CITY OF ALBUQUERQUE

February 29, 2012

Re: Juan Tabo Hills Unit 3A
Grading & Drainage Plan, Plat and Infrastructure List
Engineer's Stamp dated 2-19-12 (M22/D015)

JUAN TABO HILLS UNIT - 3A
GRADING & DRAINAGE PLAN

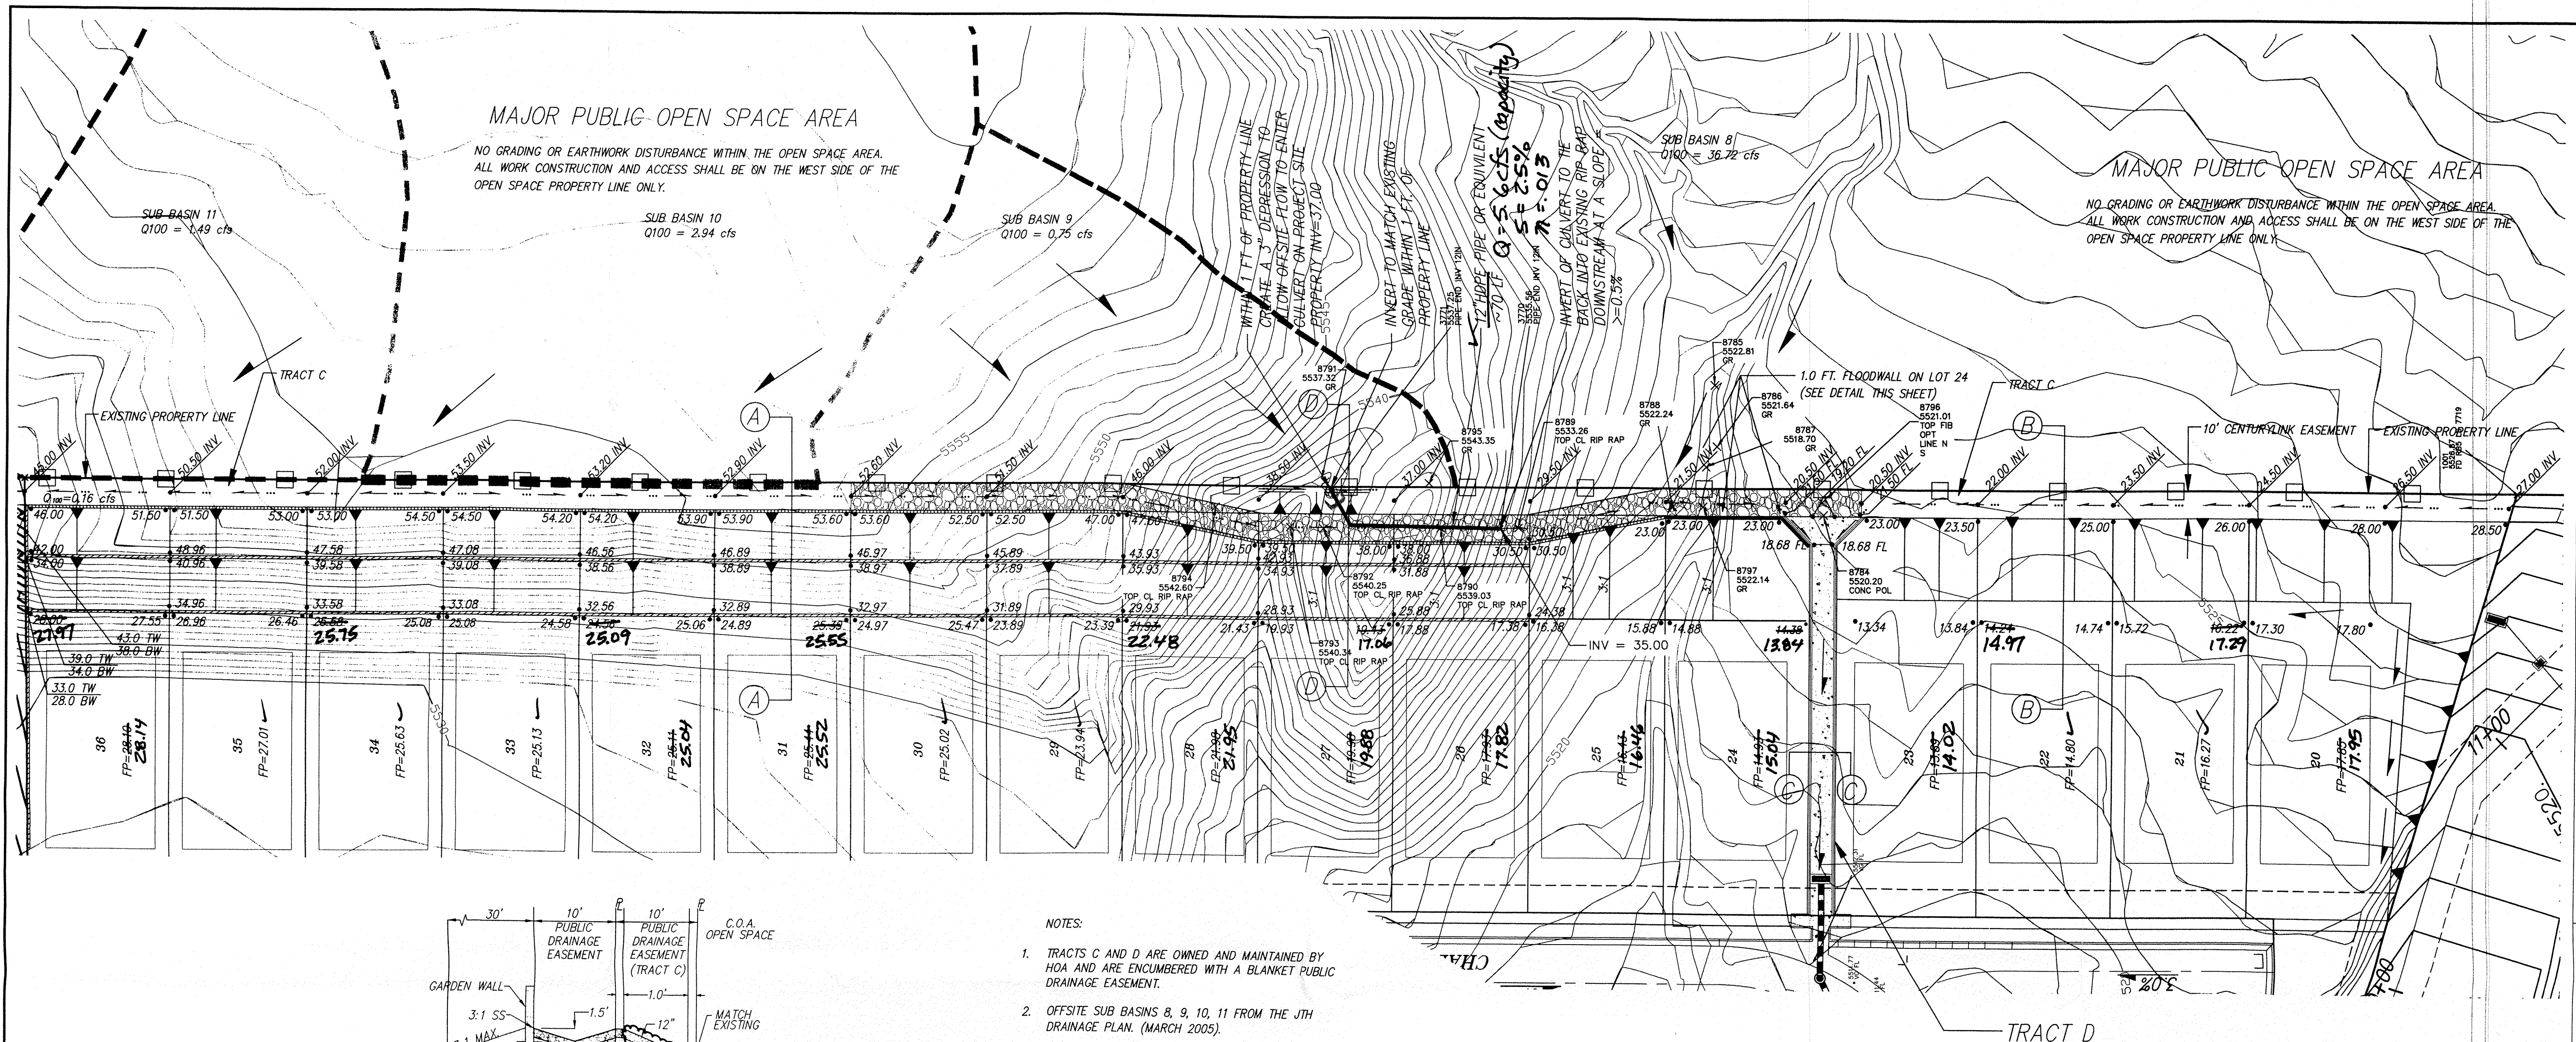
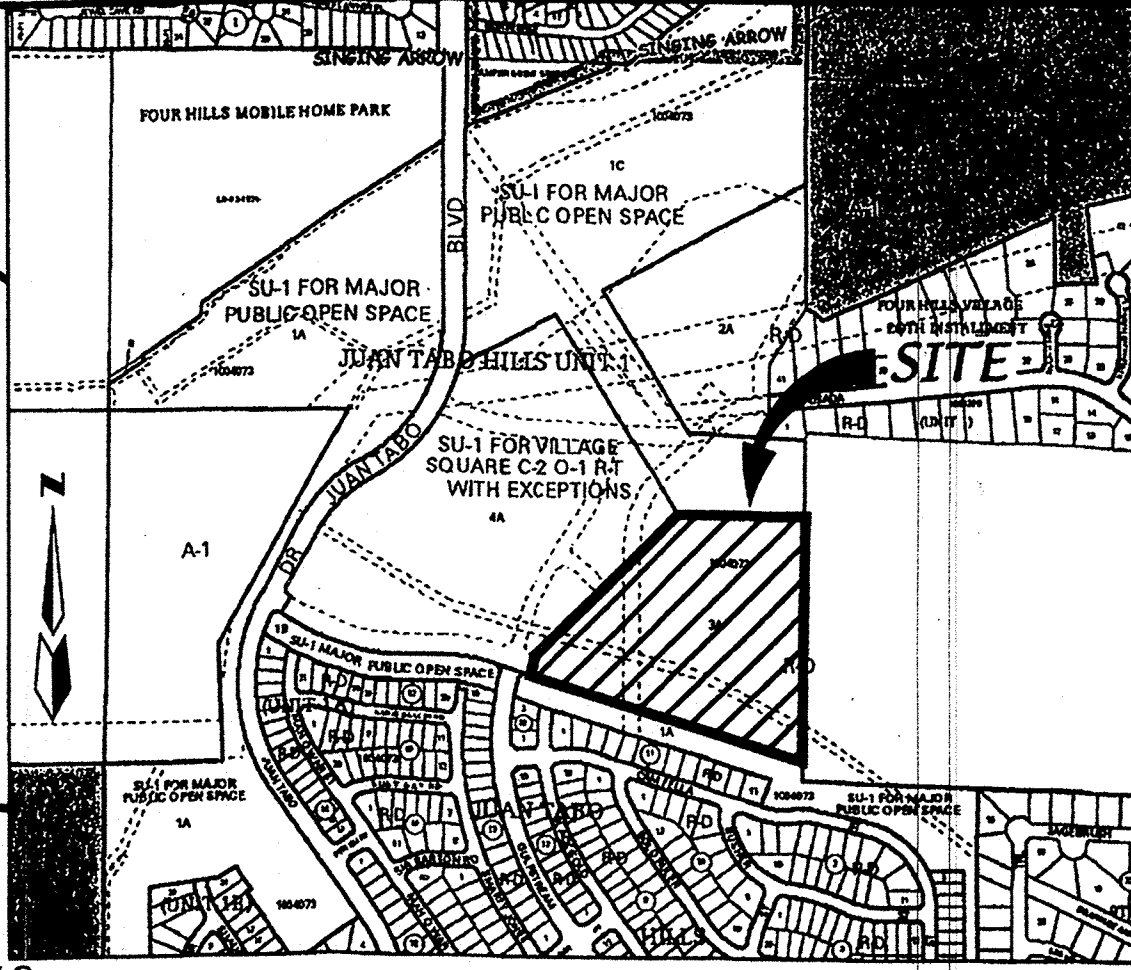
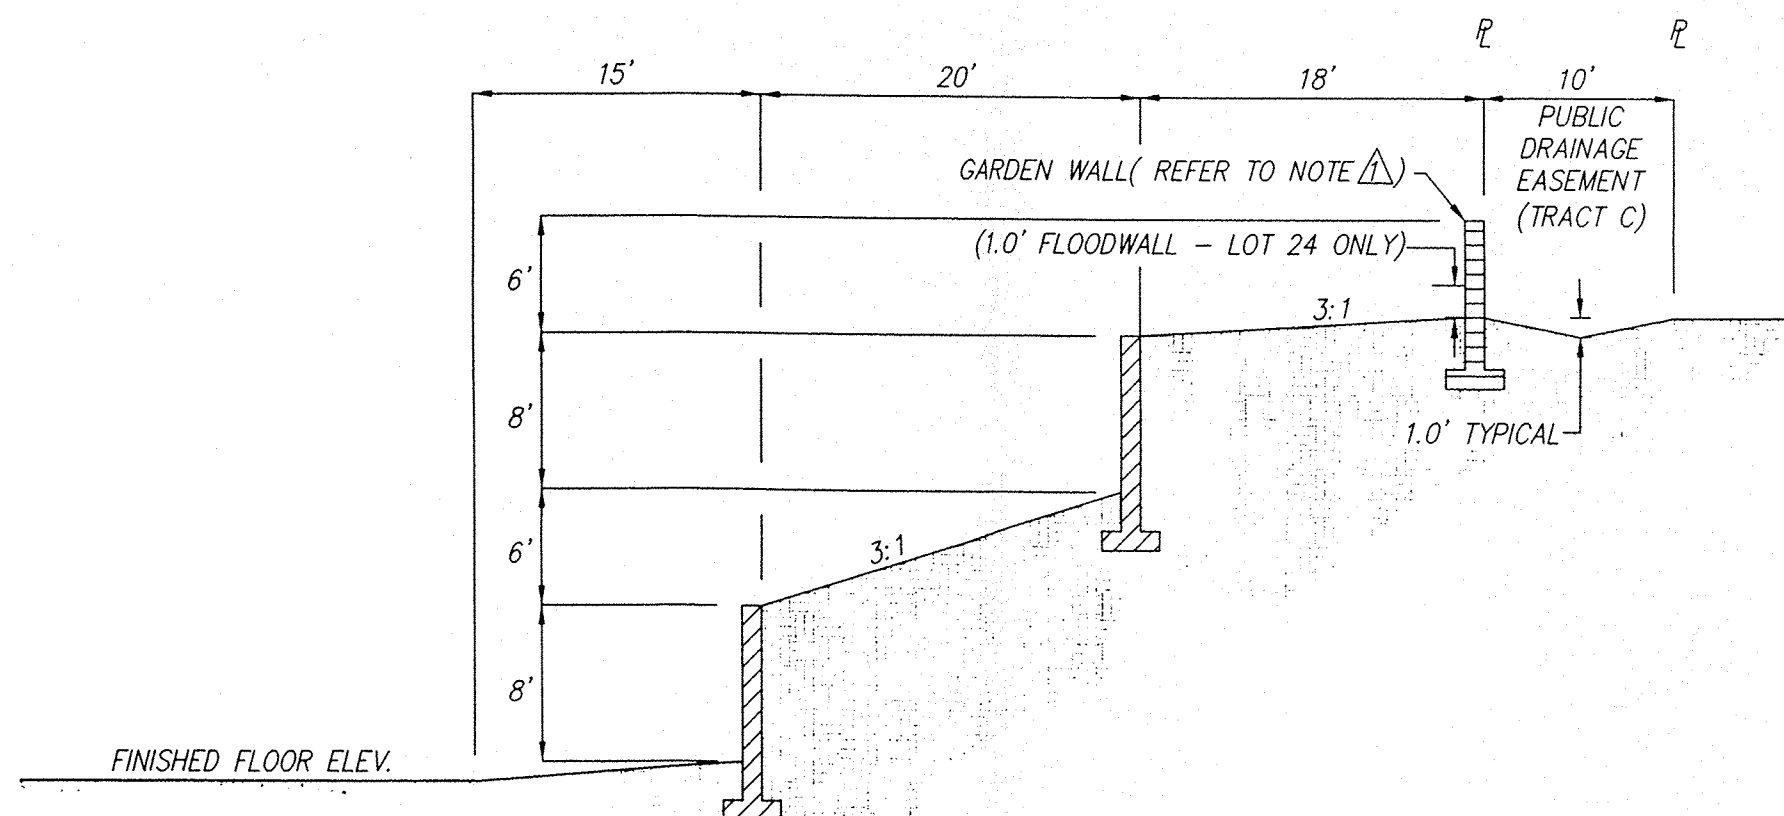
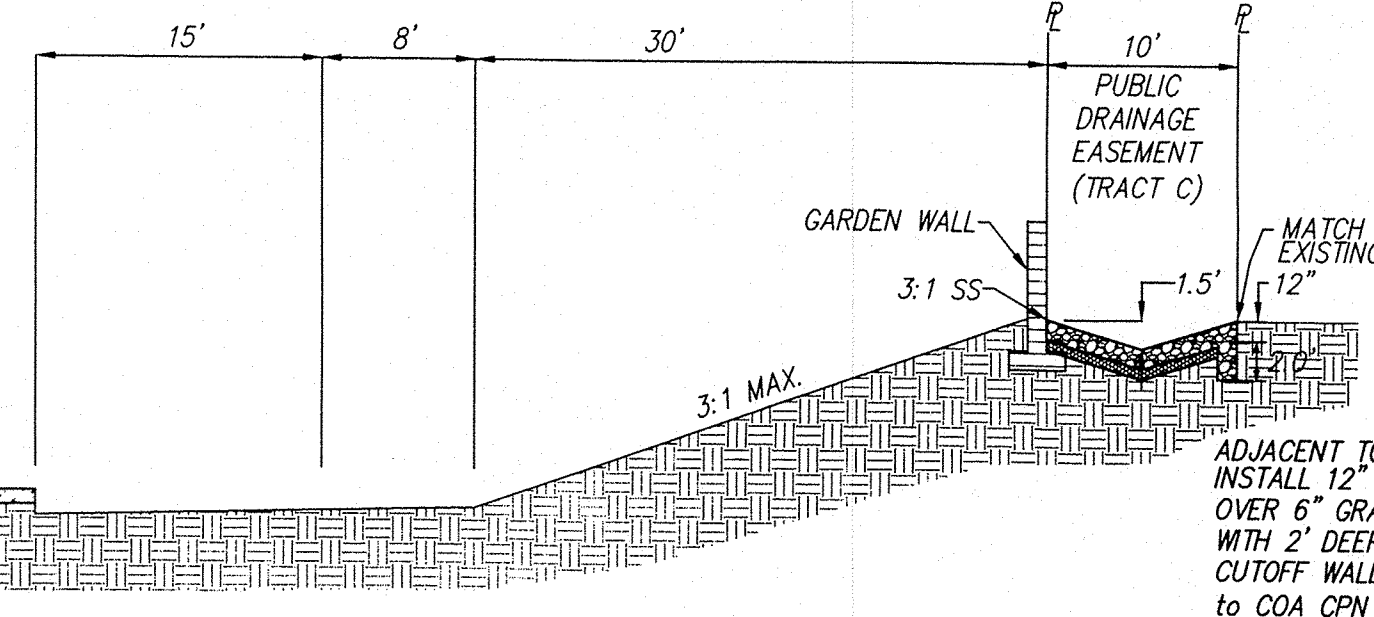
- Are the side yard retaining walls being built by the builder? If so, please indicate this on the plans with a note.
- Walls taller than 8 feet require a variance from zoning. It appears a variance is needed for the walls between the dwellings on Dahlia and Giacomo Avenues.
- How is protection from erosion being addressed to the east of the subdivision? The previous plan showed wired enclosed rip rap.
- The report calls for two temporary retention ponds. Why has one of the ponds been removed?
- The retention pond shown should be moved to a lower elevation. Top of pond is shown to be 87.50, existing grades in proposed location are 7.5 feet higher on the south side.
- Add a typical lot layout.
- Include the retaining walls between the subdivision and open space on the infrastructure list.
